Andrew Beattie - Equestrian Centre

From: "Keren" <kerenrice@gmail.com>
To: <plan_comment@nsw.gov.au>
Date: 17/12/2012 1:00 PM
Subject: Equestrian Centre

The Issues Associated with the Design of the Proposed Relocation of the Berry Equestrian Centre

This submission concerns the impact of the proposed Foxground and Berry Bypass on the Berry Equestrian Centre which is located in North Street Berry.

Berry Equestrian Centre
Horse Float, Horse Truck
and Car Parking Area

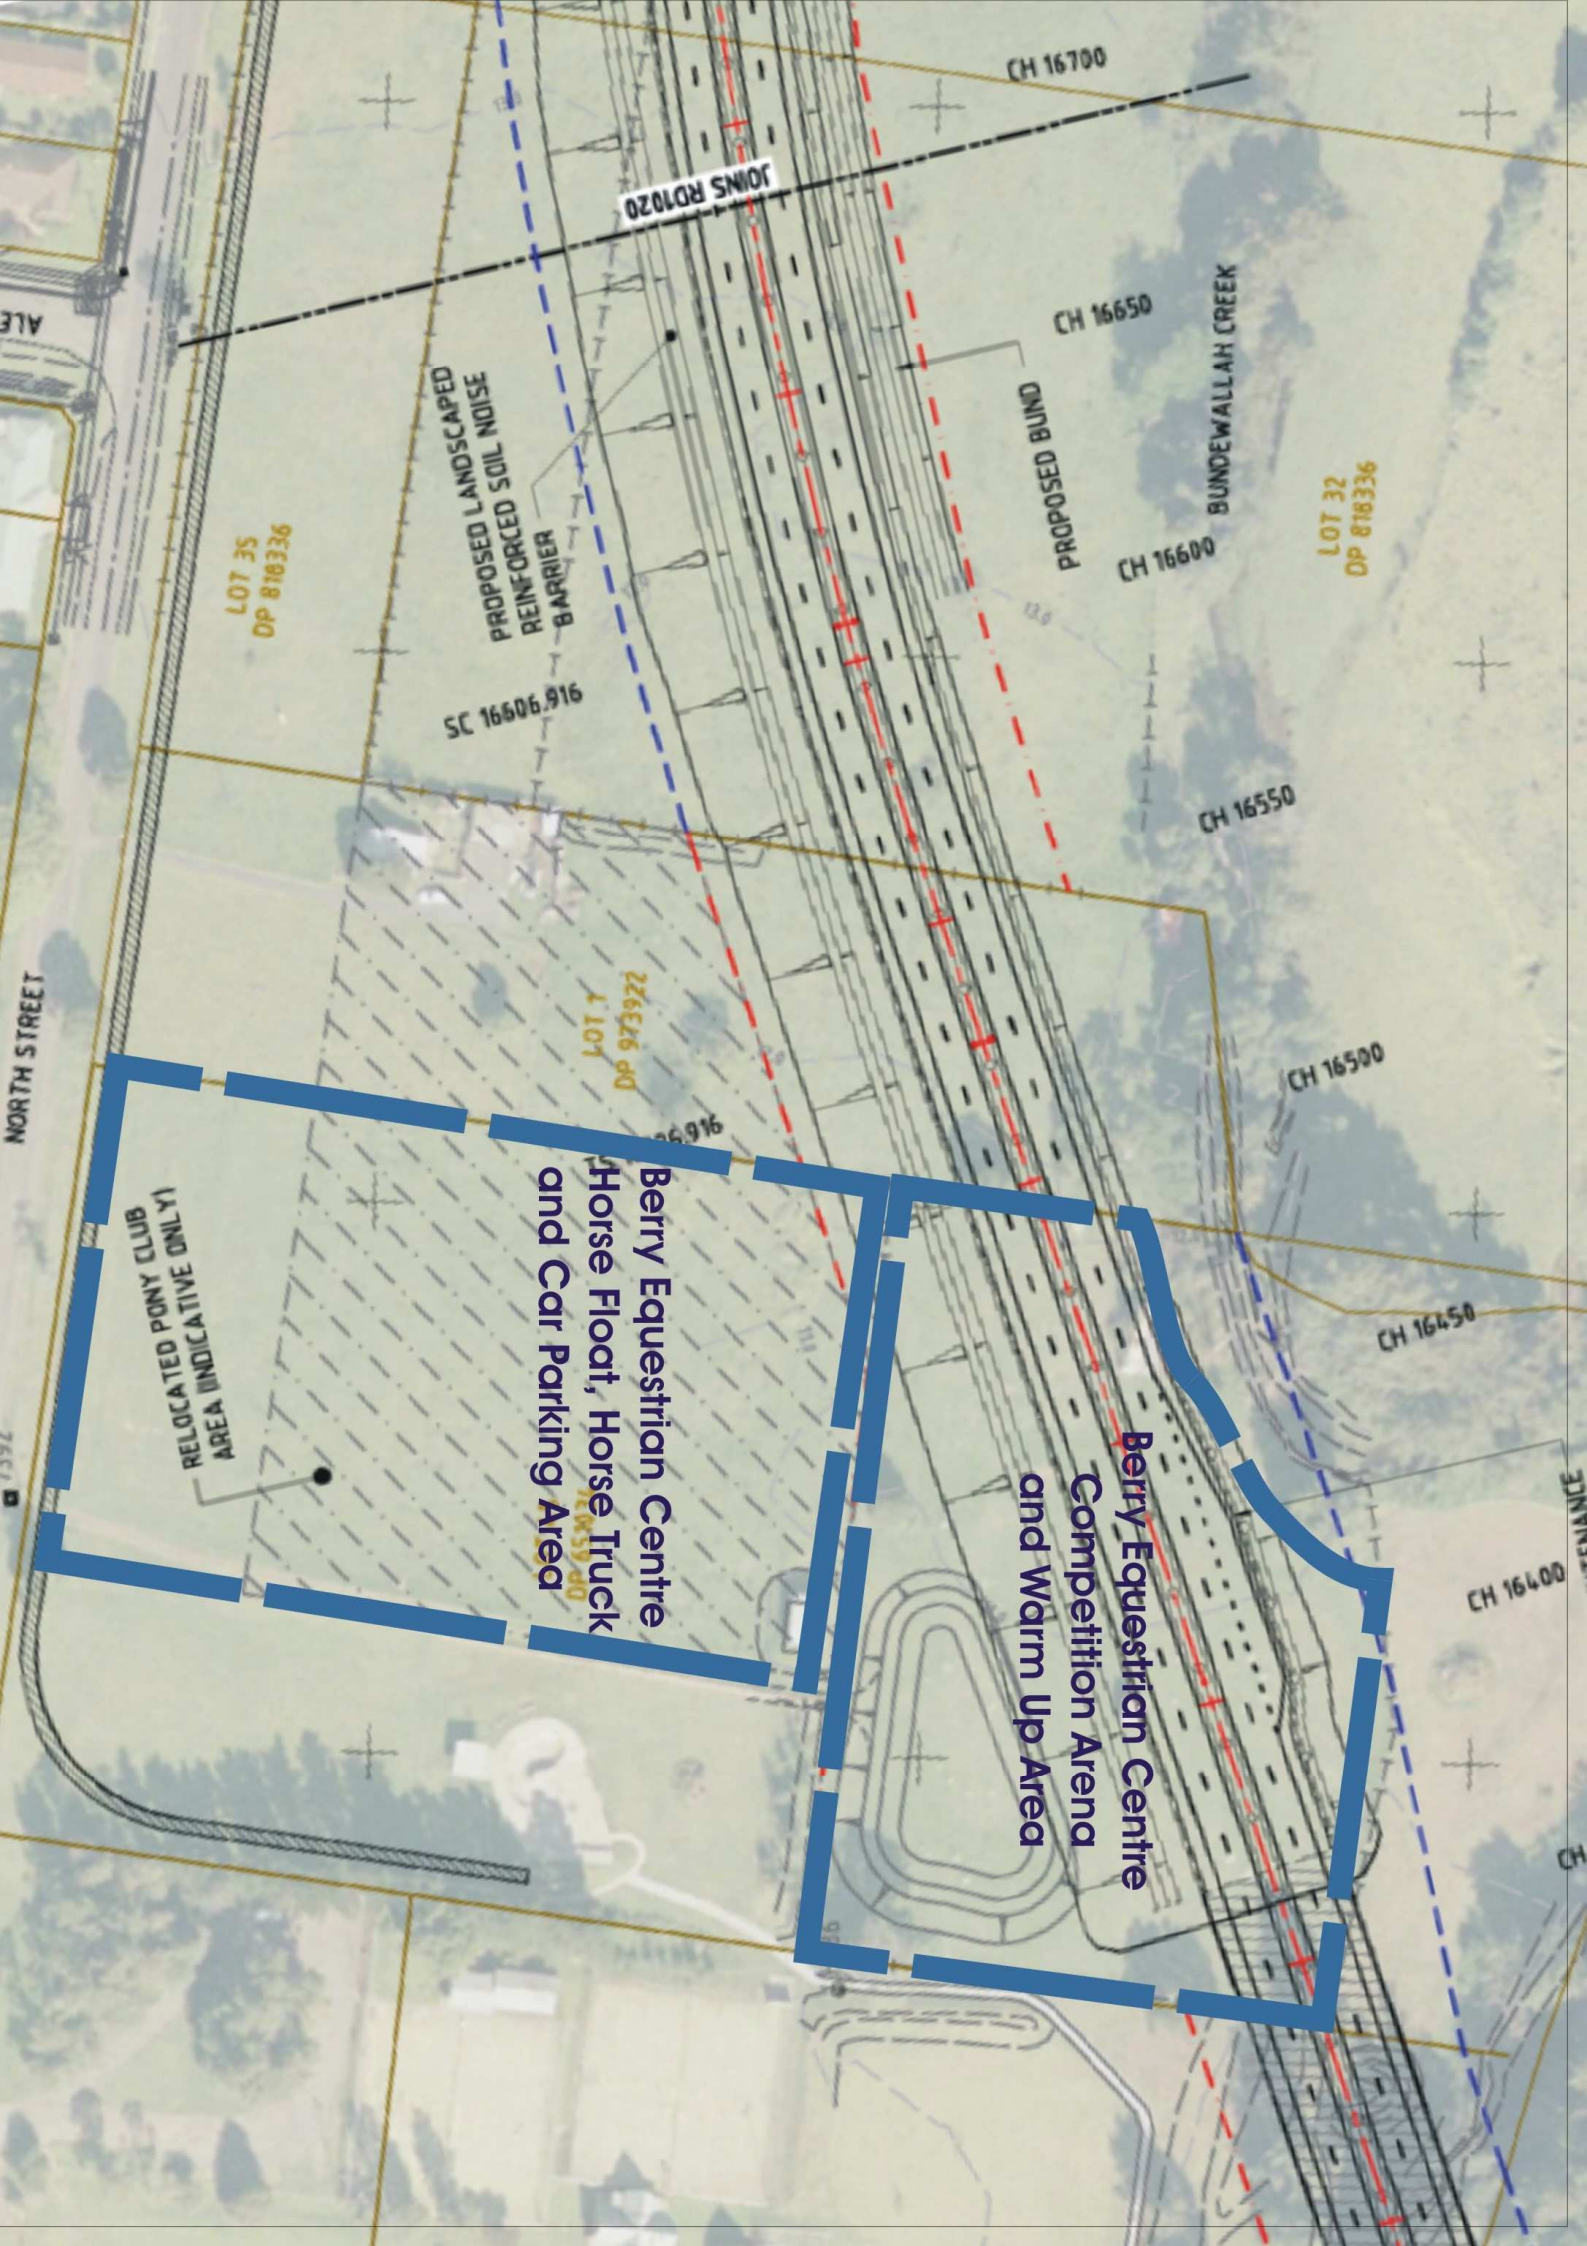
1. The competition grounds are required to be rectangular /square in shape of a minimum size of 140 metres x 140 metres with a level, well drained, good riding surface in order to cater for at least 4 dressage arenas or 2 showjumping arenas.

2. The parking area is required to be of a minimum area equivalent to 90 metres x 160 metres and allow for easy entry, maneuverability, parking and exit of horse floats and trucks. Each parking space is equivalent to an absolute minimum of 4 normal vehicle spaces due to the need for unloading/loading and tie up areas for horses.

3. There is concern for the safety of horses, riders and the general public due to the near location of the proposed riding area to the 4 lane expressway, the skateway, the public cycleway/walkway and North Street. There will be anticipated significantly increased noise and visibility of cars and trucks travelling at 100km/hour on the expressway with horses competing nearby, often with young, very inexperienced riders.

4. Access to the grounds is likely to be across a public shared cycleway/pathway. The safety of children on skateboards, bicycles etc are at risk as horse trucks and floats cross the pathway. Horse floats and trucks also require an indented driveway of at least 15 metres to allow vehicles to park off the roadway whilst gates to the grounds are opened.
